2022/0462

Erection of two storey extension to front, first floor extensions on side and rear/side, single storey extension to rear/side, replacement roof including changing from gable ends to hipped roof style and rendering of the external walls of the dwelling

35 Armroyd Lane, Elsecar, Barnsley, S74 8ET

Front Elevation.  
as Proposed.

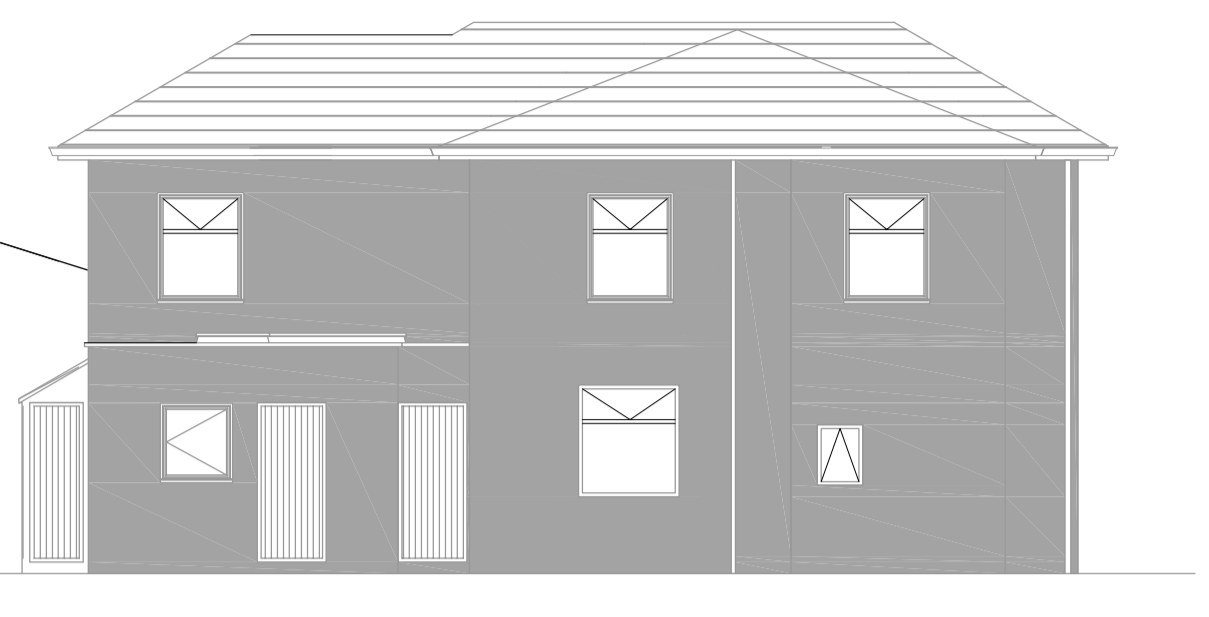
Whilst being two storey, the front extension effectively infills the existing canopy/gap which is located to the front of the dwelling. The overall shape and symmetry of the dwelling is retained through this extension which projects to the front by a restrained amount (1.05m). The design of the front extension also introduces dark tinted glazing with aluminium curtain walling which is a high quality construction material, common on modern developments. The design of the front extension is considered to be acceptable

The development seeks to render the majority of the external walls of the dwelling. Render is a common feature on Armroyd lane with the existing property also containing render on the first floor. However, there were concerns that the amount of render and the increase in the size of the dwelling would lead to the dwelling being prominent within the street scene. The development also included the render of the retaining wall to the immediate front of the dwelling. As such, an amended plan was received which reduced the amount of render on the front elevation of the dwelling with the introduction of red brick to the front and either side of the two-storey front extension, and the retention of the existing brick retaining wall to the front of the dwelling.

These features remaining in brick are intended on breaking up the increased rendering on the property and retaining the existing character which is a mixture of red brick and render. Confirmation has also been received by the applicant in terms of render colour (Buttermilk/off-white), the exact specification for the red brick, roof tile colour and window colour. All of which are considered in keeping with the existing and the surrounding area. Buttermilk render is off-white, with a stone/yellow tint, which is similar to the render which is on the existing dwelling. The combination of render and light grey (RAL7016 windows is a common feature on modern residential developments and is considered to be suitable in terms of good design and the development's impact on visual amenity.

Side Elevation.  
as Proposed.

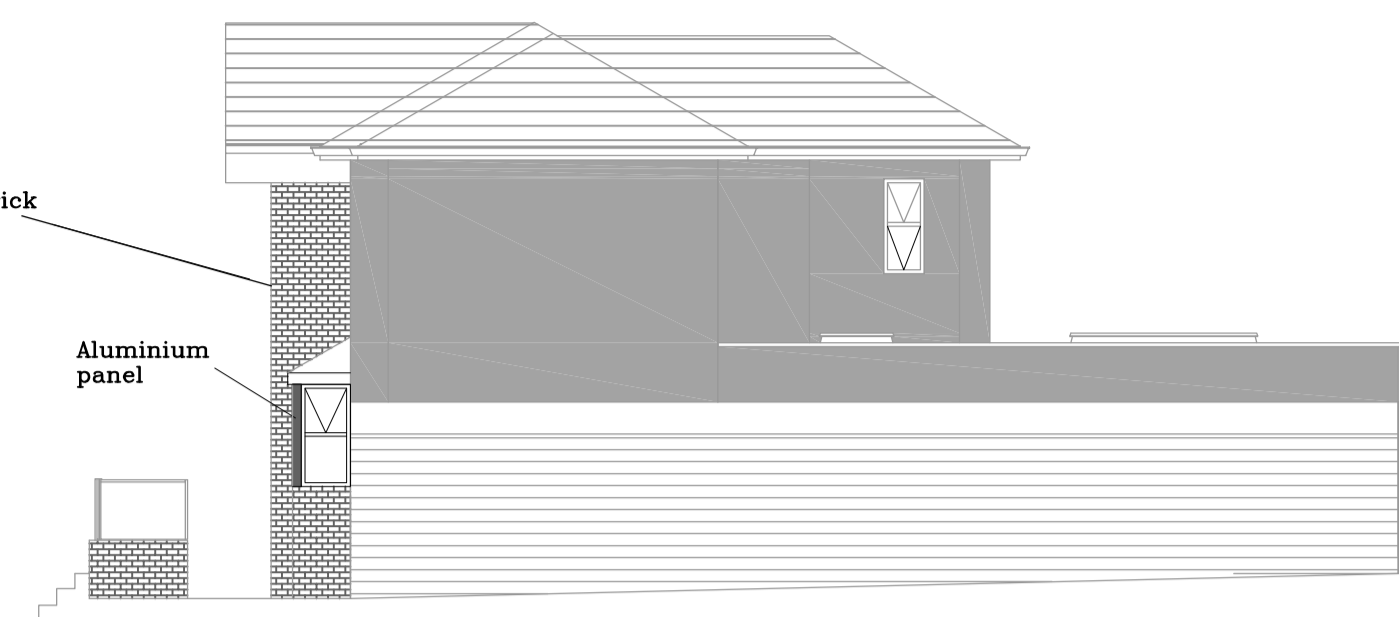
The development includes the erection of a first storey side extension which now features a set back and a set down (amended plans). It is not excessively sized, having a sideways projection of less than two-thirds the width of the existing dwelling and is subservient to the host dwelling.

The first-floor side/rear extension to the Western side is effectively positioned behind the dwelling and will largely be screened from the street. In any case, the amended plans show that this extension will feature a hipped roof to join up to the existing roof line – rather than the originally proposed flat roof. It does not have an excessive sideways or rearwards projection and is acceptable.

The roof design of the dwelling seeks to amend from a standard pitched/gable end roof to hipped. Armroyd lane is diverse with many different types of properties with various roof styles. Hipped roofs are a common feature in the street and this roof type alteration is considered to be appropriate.

Front window detail  
as Proposed.

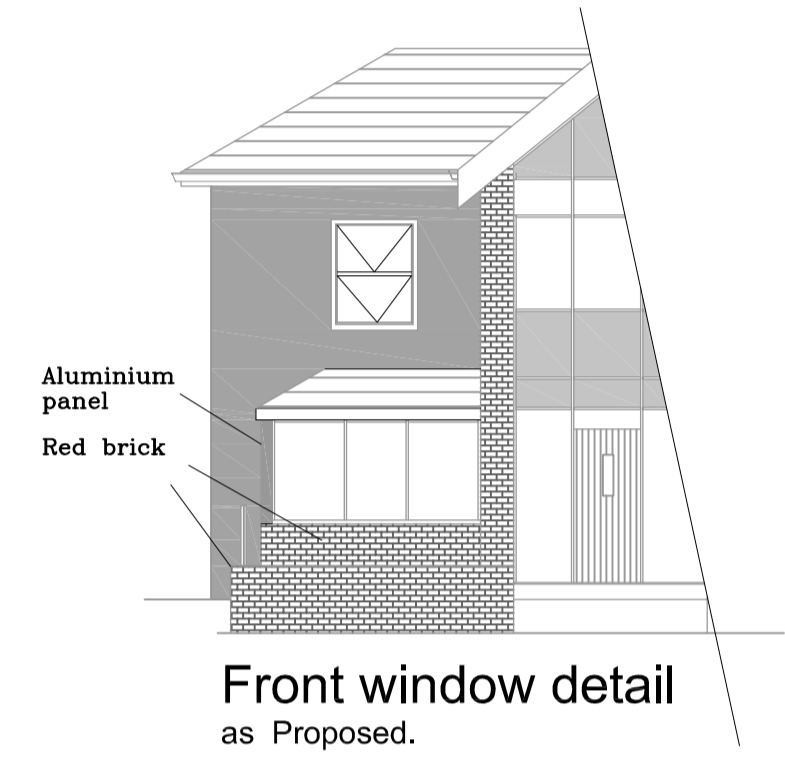
The existing bow window to the front are being altered from a bow window into a bay window, with a hipped roof which is similar to the proposed new roof style/type of the main part of the dwelling. Additionally, the window style on the bay windows are being altered with increased glazing which is considered to fit into the overall design of the renovation and is acceptable.

Ground floor  
as Proposed.

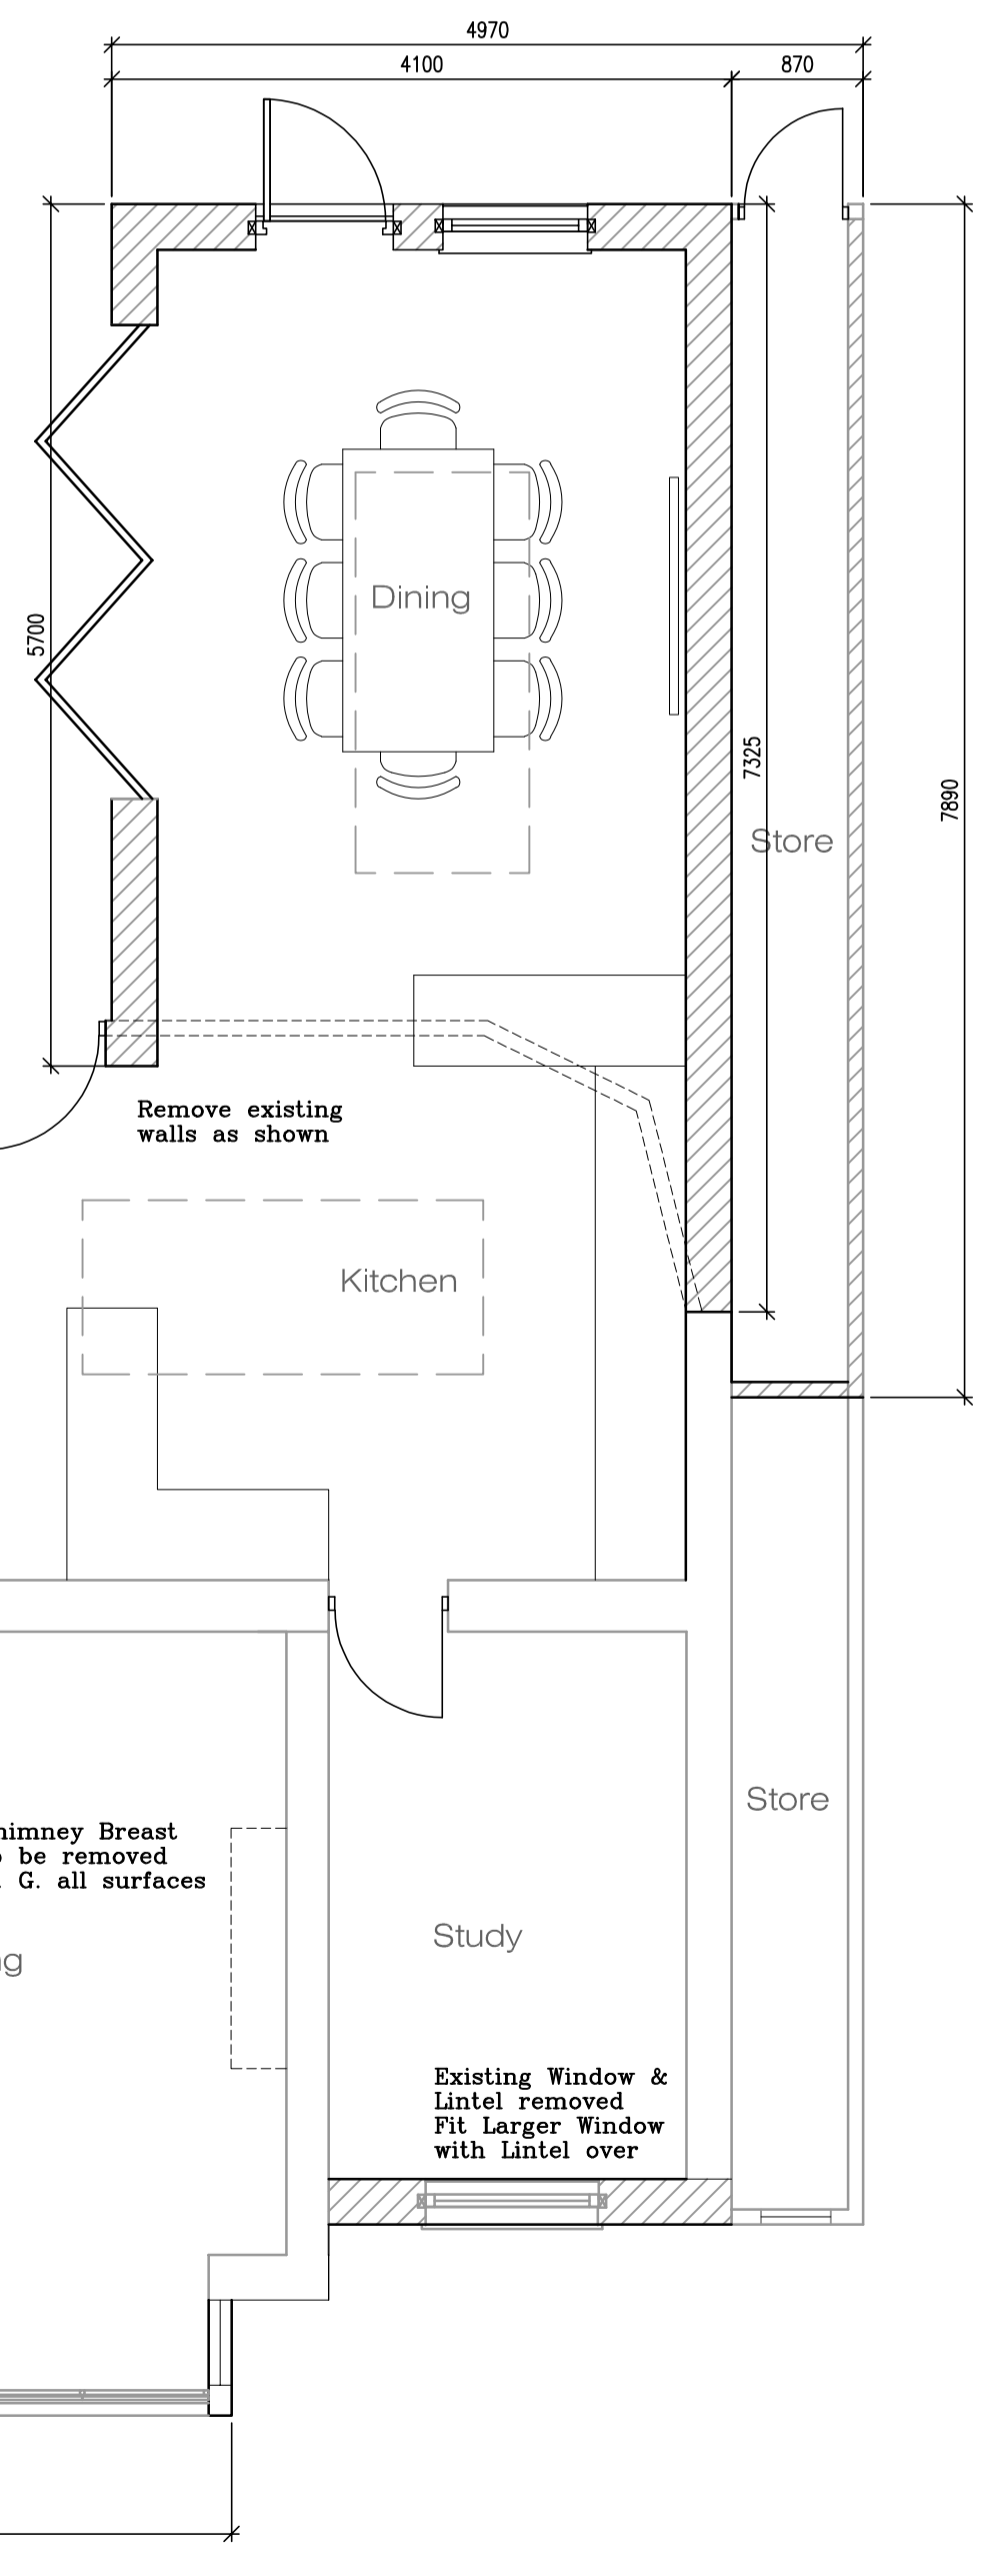
The single storey rear extension features a flat roof which is generally seen as inferior compared to pitched roof or hipped roof to match the existing dwelling. However, a flat roof single storey extension is a typical feature on more modern residential development/house renovations and the flat roof results in a reduced overall height. The extension will be almost entirely screened from the street and therefore has little impact on the character of the dwelling or the area.

The proposed single storey rear extension features a flat roof with a total rearwards projection of 7.3m. There is no defined maximum rearwards projection in the SPD for single storey extensions to detached properties and the extension will replace the existing conservatory attached to the rear of the dwelling. The single storey rear extension is immediately adjacent to no. 33's detached garage, projecting passed this by 2m which is not an excessive amount. The overall overshadowing and overbearing impact is limited given that the extension is single storey but any such impact would be primarily on the neighbouring garage and not on the rear garden to an unreasonable amount.
